CITY OF ALBUQUERQUE

**Re: The Boulders Phase 1 Subdivision, Lots 1-34, 39-131, Grading Plan
Certification—Approved
Engineer's Stamp date 5-6-11 (B11/D001B)
Certification date 04-24-12**

RONALD R. BOHANNON P.E. #7868	ENGINEER'S SEAL	THE BOULDERS PHASE 1	DRAWN BY DY
		RETAINING WALLS	DATE 05-06-11
		TERRA WEST, LLC 5571 MIDWAY PARK PLACE NE ALBUQUERQUE, NM 87109 (505)858-3100 terrawestllc.com	2011005-SH01-02- GRE-PH1
			SHEET # 3 OF 20 3 BOULDER SECTION JOB # 2011005

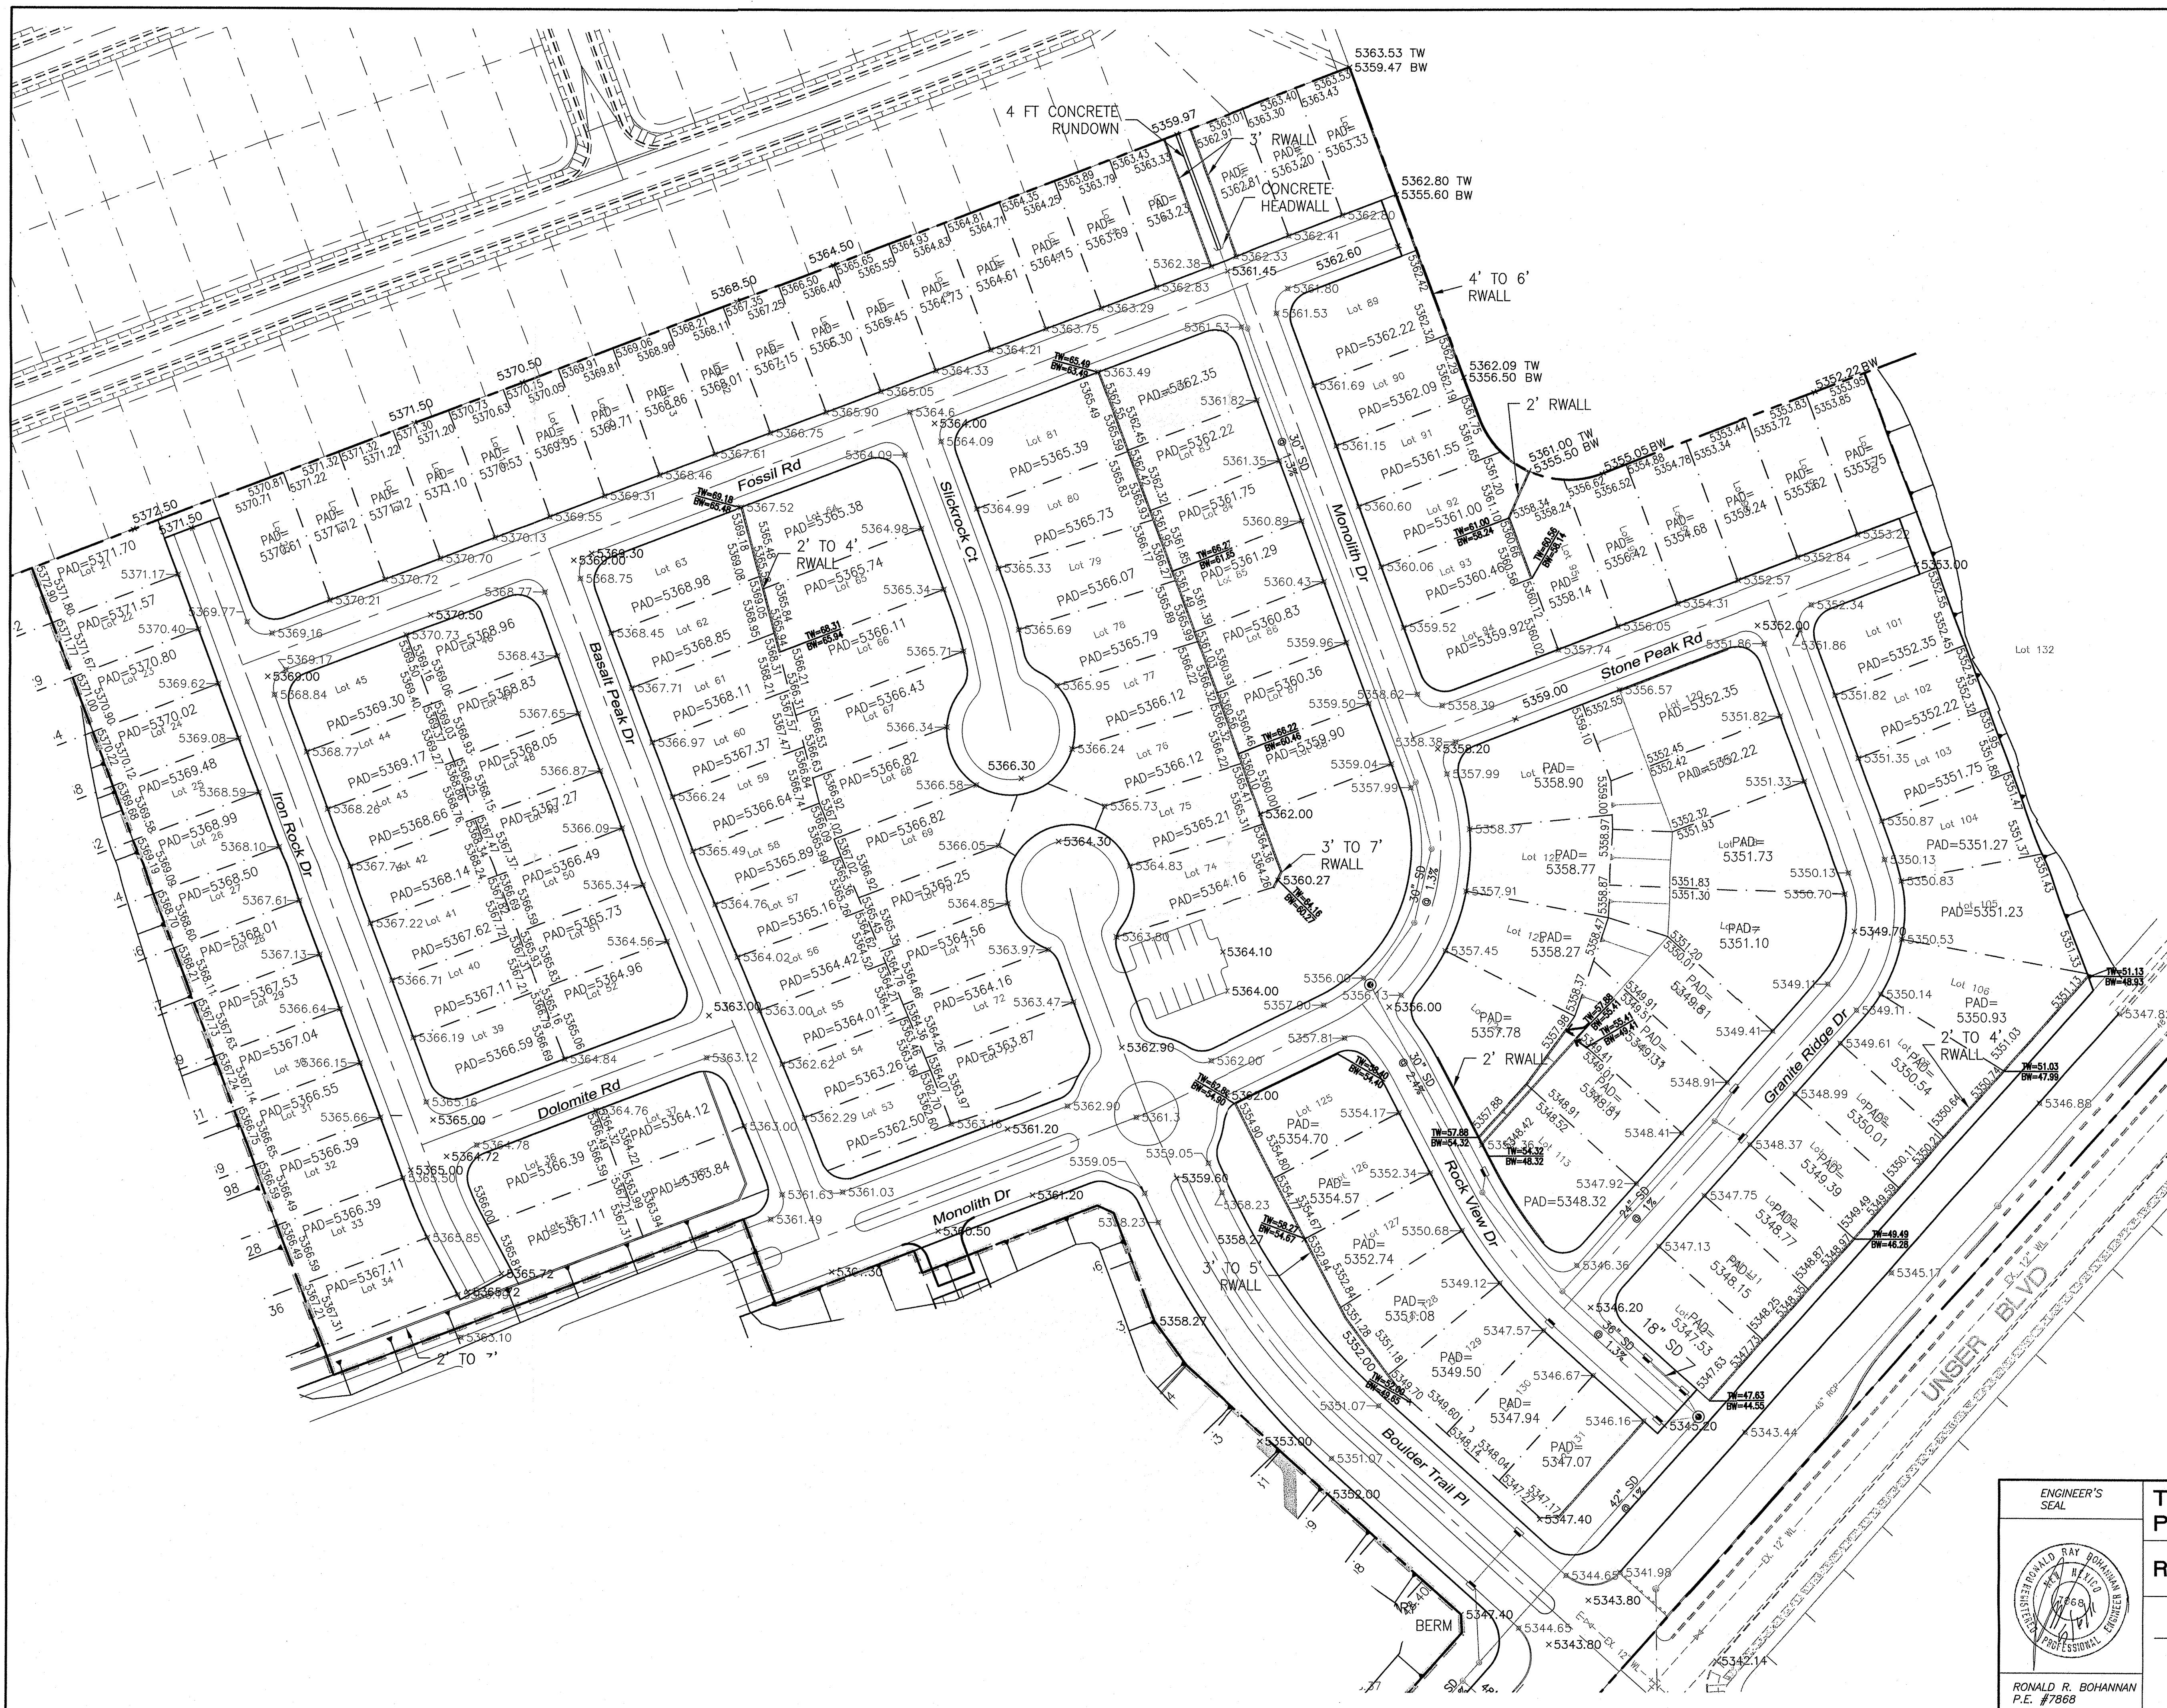
After a site visit lots 35, 36, 37, and 38 require additional a retaining wall in the rear yards due to the grade change. In addition, the certifying language will need to reflect the correct request of the certification, (ie. pad certification, C.O., and release of financial guarantee.) This certification is for pad certification; in your language it states "...in support of building certificate of occupancy issuance..." at this time no buildings are constructed. Please amend this in the future.

Top of wall and bottom of wall will need to be certified at time of release of financial guarantee.
